KIRKLEES METROPOLITAN COUNCIL INVESTMENT & REGENERATION SERVICE

DELEGATED DECISION TO DETERMINE PLANNING APPLICATIONS

Reference No:	2023/62/93248/W
Site Address:	24, Marten Grove, Netherton, Huddersfield, HD4 7JU
Description:	Erection of single storey rear extension and garage conversion
Recommending Officer:	Molly Storer

HOUSEHOLDER DELEGATED REPORT

Drawn	DRH
Date	August 2023
Scales	1:100 @ A3
Drawing No.	2384 - 0301 - P01

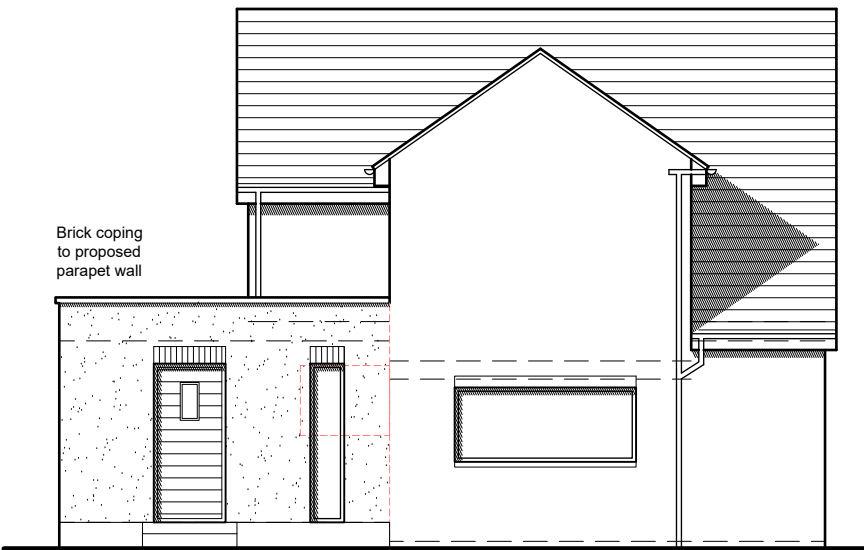
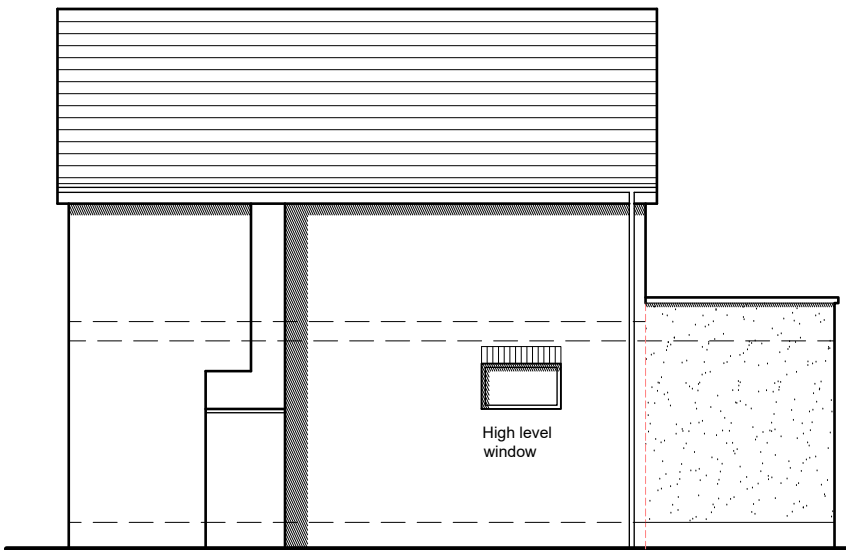
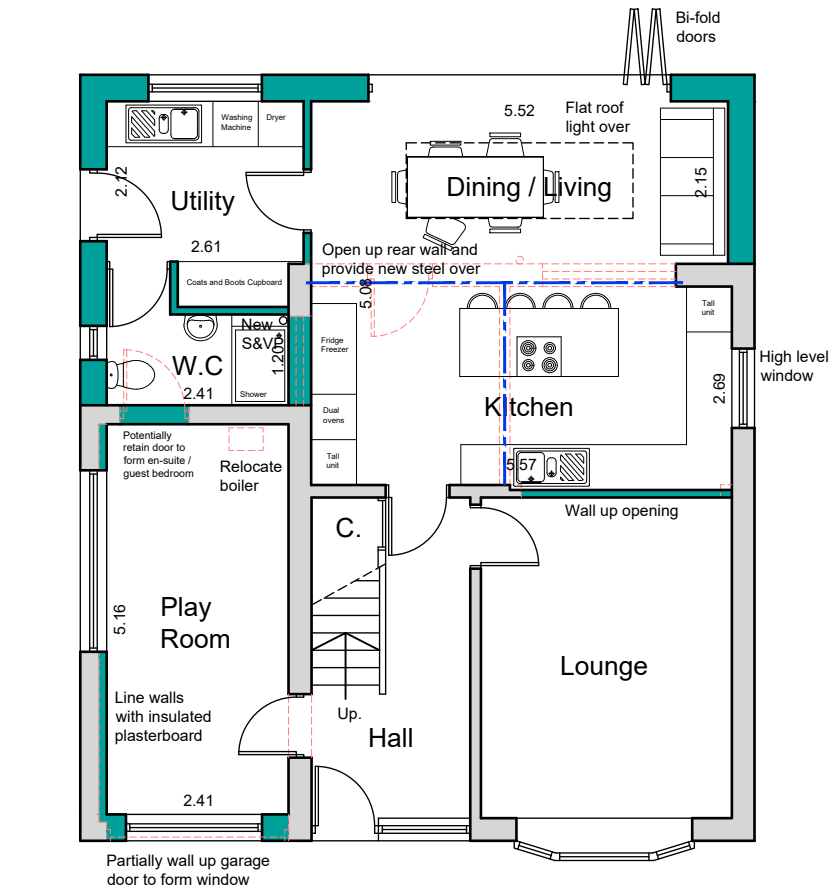
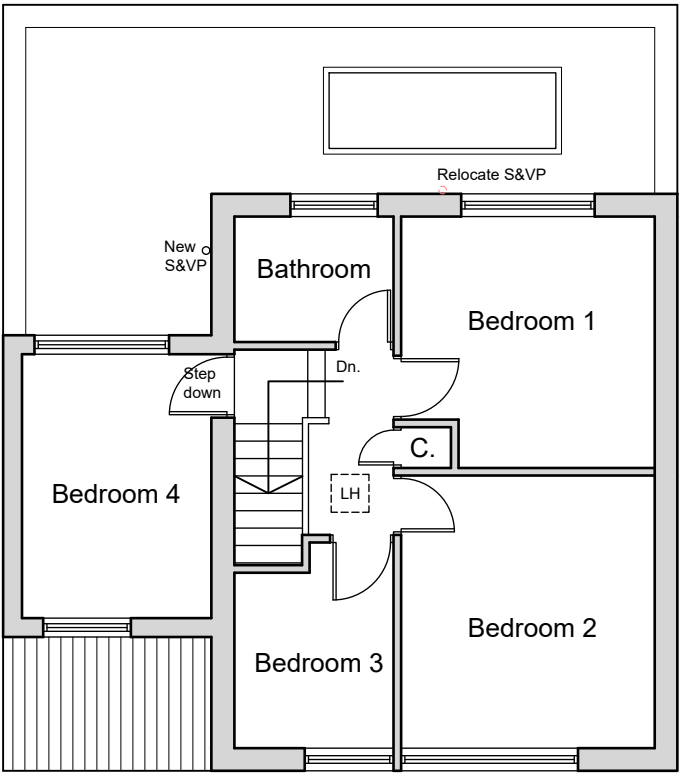
The extension would have a maximum height of 3.2m with a flat roof design with parapet walls. It would project 4.4m from the playroom and 2.5m from the kitchen with an overall width of 8.9m. This would create an open plan kitchen and dining area in addition to a utility room and bathroom. These are maximum dimensions as the structure would be 'L' shaped to infill the area to the rear of the garage and extend across the width of the dwelling. The garage would be converted to a playroom. The garage door would be removed and replaced with a window.

not exceed 4 metres in height	Yes- does not exceed 4 meters in height	
not project out more than 3 metres from the rear wall of the original house for semidetached and terraces houses or by 4 metres for detached properties		No- the projection from the playroom rear wall is 4.4m, however this is justified as less than half of the proposed extension will project more than 4 meters from the rear wall. Due to the property being detached and in a substantial curtilage the

additional 0.4m is not considered grounds for refusal.
where they exceed 3m in length the eaves height should generally not exceed 2.5 meters		No- the eaves would be 3.3m due to the flat roof design. This design helps to reduce the overall mass of the extension.
retain a gap of at least 1 metre from a property boundary, such as a wall, fence or hedge	Yes – a gap of at least 1 meter would be retained.

Window proportions	• KDP 1 and 2 of the SPD • Policy LP24 Design (a), (c) and (d) of the KLP • Chapter 12 of the NPPF	There would be large bi-folding doors and an additional window of the north elevation facing into the rear garden. A small high level window is proposed in the east (side) elevation. A frosted glazed full length window in the west elevation and a new window in the south elevation where the garage has been walled up in place of the garage door.	✓
Accessibility for all users	• KDP 17 of the SPD	Private domestic extension- no alterations to general access.	✓

Relevant key design principle (KDP) of the SPD, Policy in the Kirklees Local Plan and the NPPF	Further comments	✓ / X / N/A
Impact on privacy of neighbours (to sides, rear and front)	• KDP 3 & 4 of the SPD • Policy LP24 Design (d) (iv) • Chapter 12 of the NPPF	There is one proposed opening in the original east elevation however due to the orientation of the houses, No.22 is set on a building line further forward meaning there	✓

will be limited impact on privacy and the window is high level. The west elevation will host a door and a full length window. This window will have frosted glazing so will limit impact of privacy to No.49. In regard to the properties to the rear, the north elevation will host large bifolding doors and a single window. Although these will face No.44 and 46 Marten Drive the extension will still be at a significant distance away (~7 meters) from the boundary line. In addition, the existence of a large (~1.8 meter) hedge and the existing detached garages at these properties already provide screening between the properties.	
Impact on light and outlook of neighbours (to sides, rear and front)	• KDP 4, 5, 6 of the SPD • Policy LP24 Design (b) • Chapter 12 of the NPPF	Limited impact due to being single story in height and the presence of the existing boundary fences/hedges and the separation of the structure to property boundaries. Due to the orientation of the dwellings there would be no impact on sunlight to No.22 Marten Grove and outlook would not be significantly affected. In addition, due to No.49 being on a higher ground level the extension would not impact sunlight or outlook to this property.	✓
